**RE: PROJECT NUMBER PR-2018\_001346 Alameda Mixed Use Development**

**Planning Dept. comments:**

**Transportation Development comments:****Site Plan:**

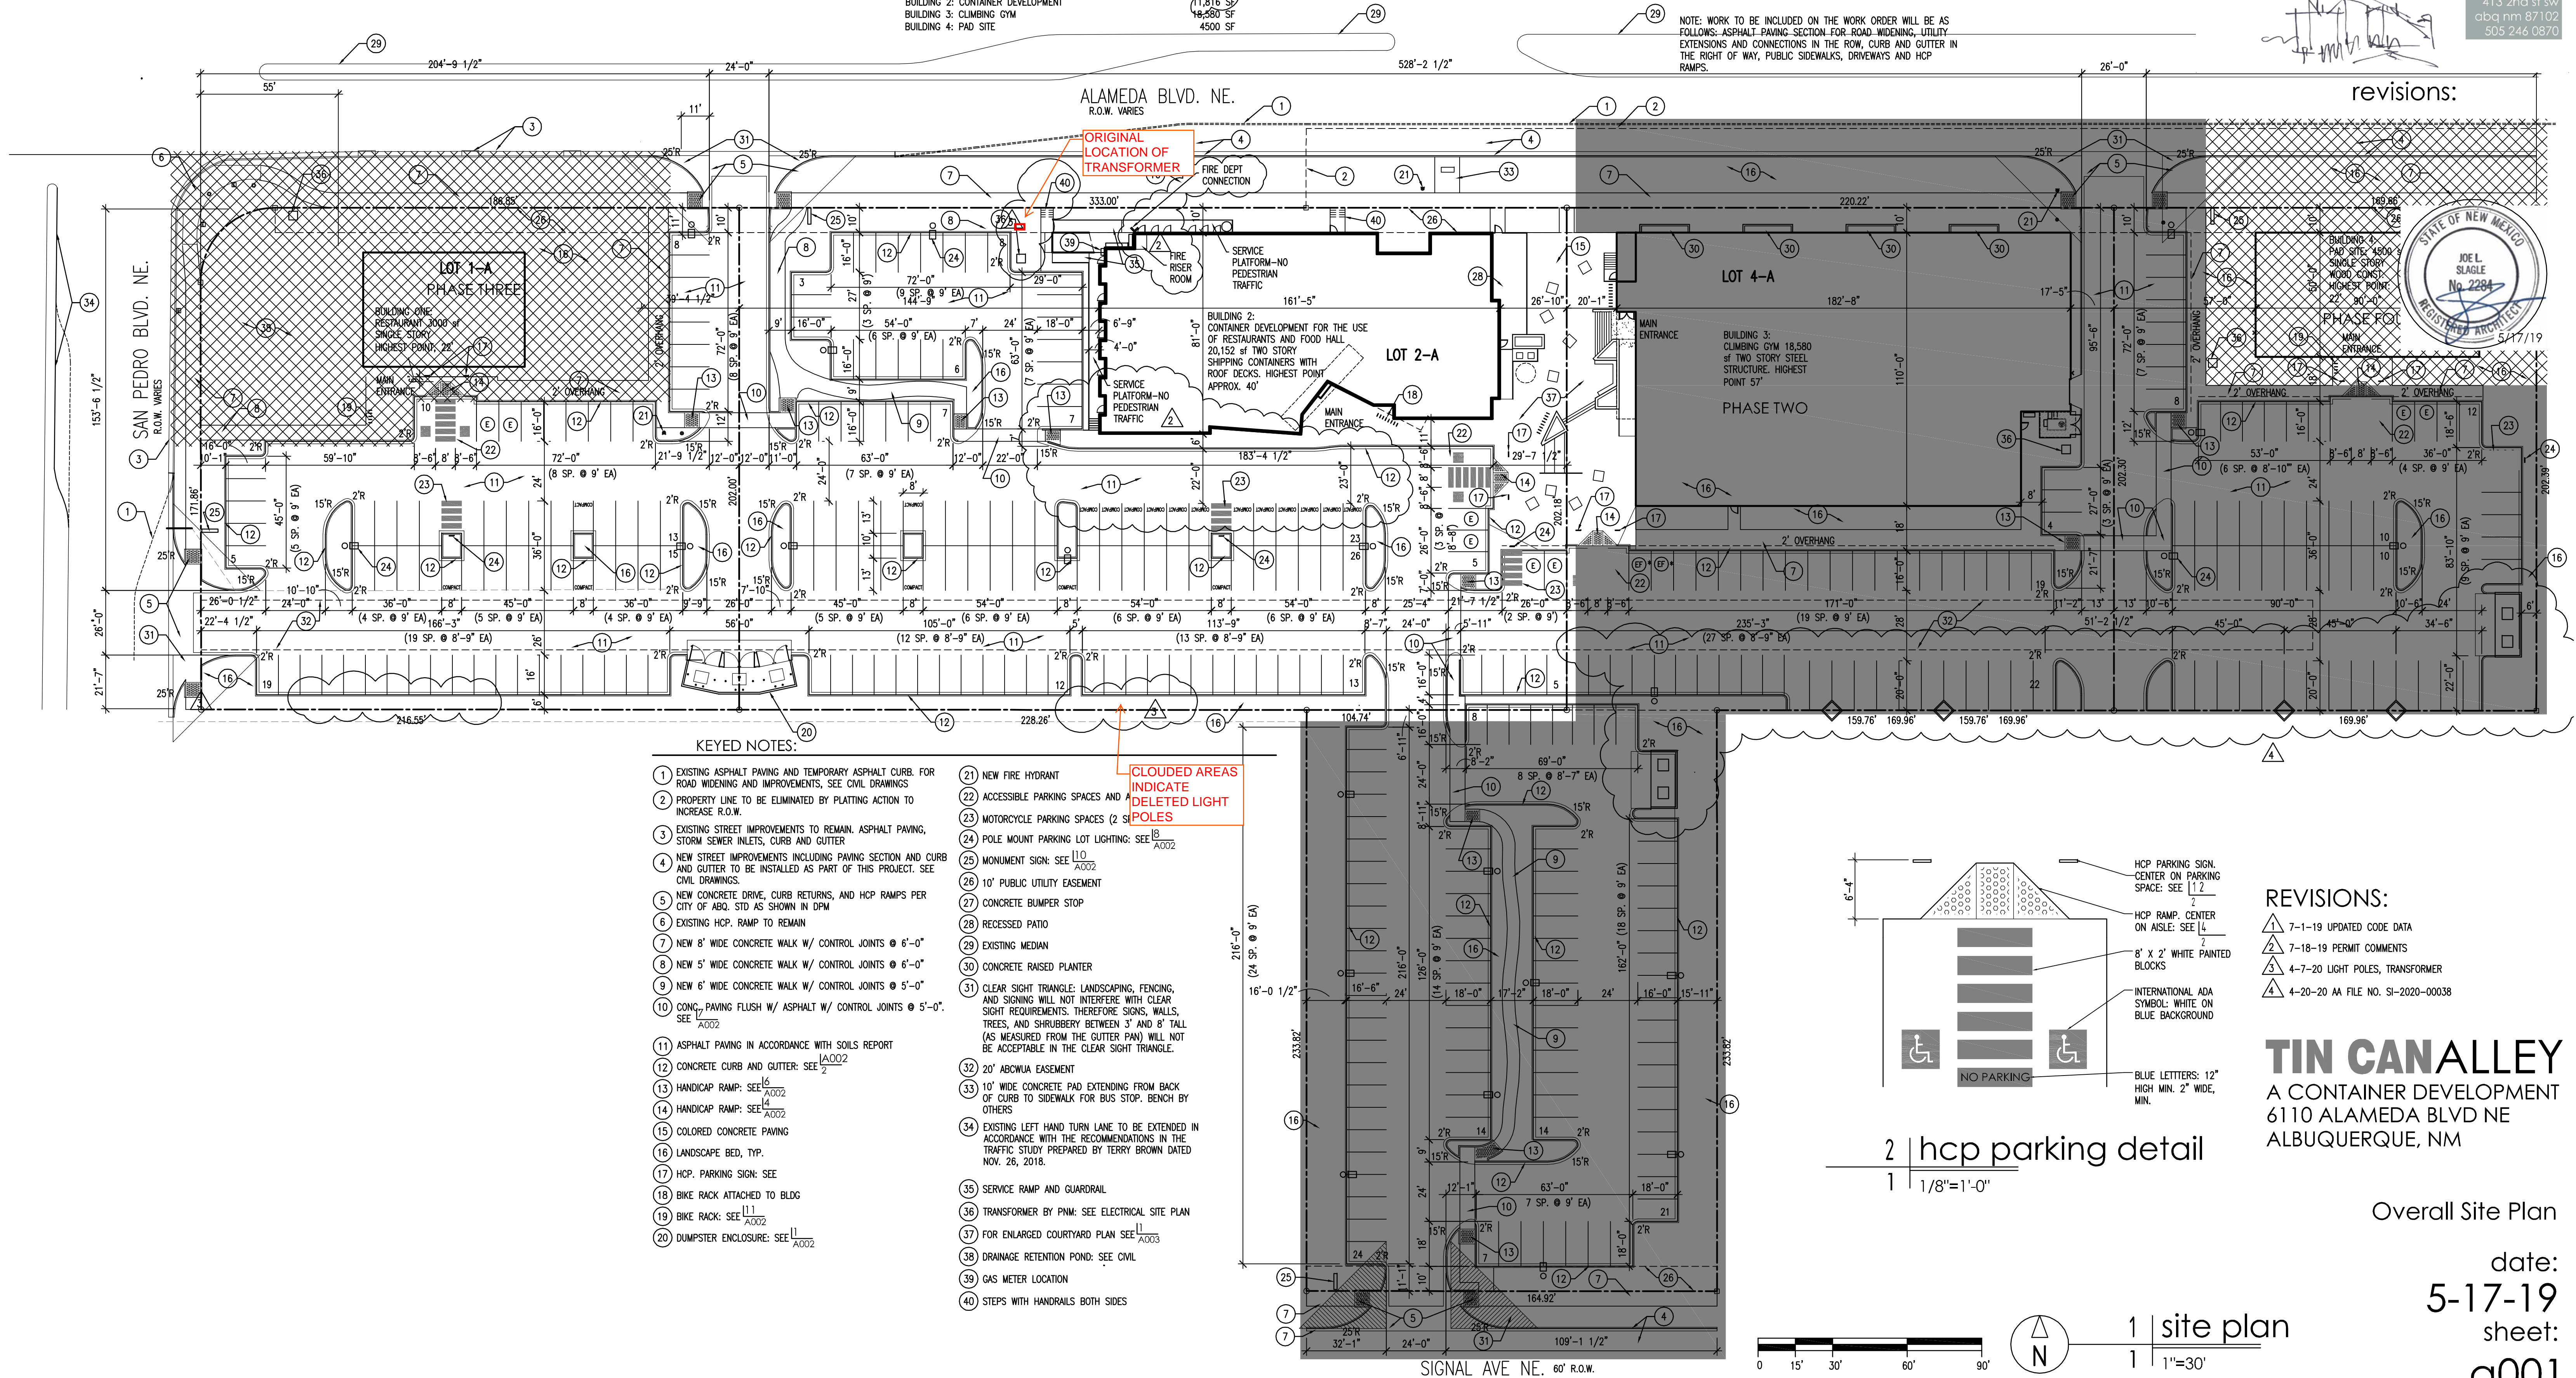
3. Dimensions of parking spaces have been added to the site plan.
4. Detail 2/1 has been added to the site plan indicating the words "NO PARKING" on the hcp. Aisle.
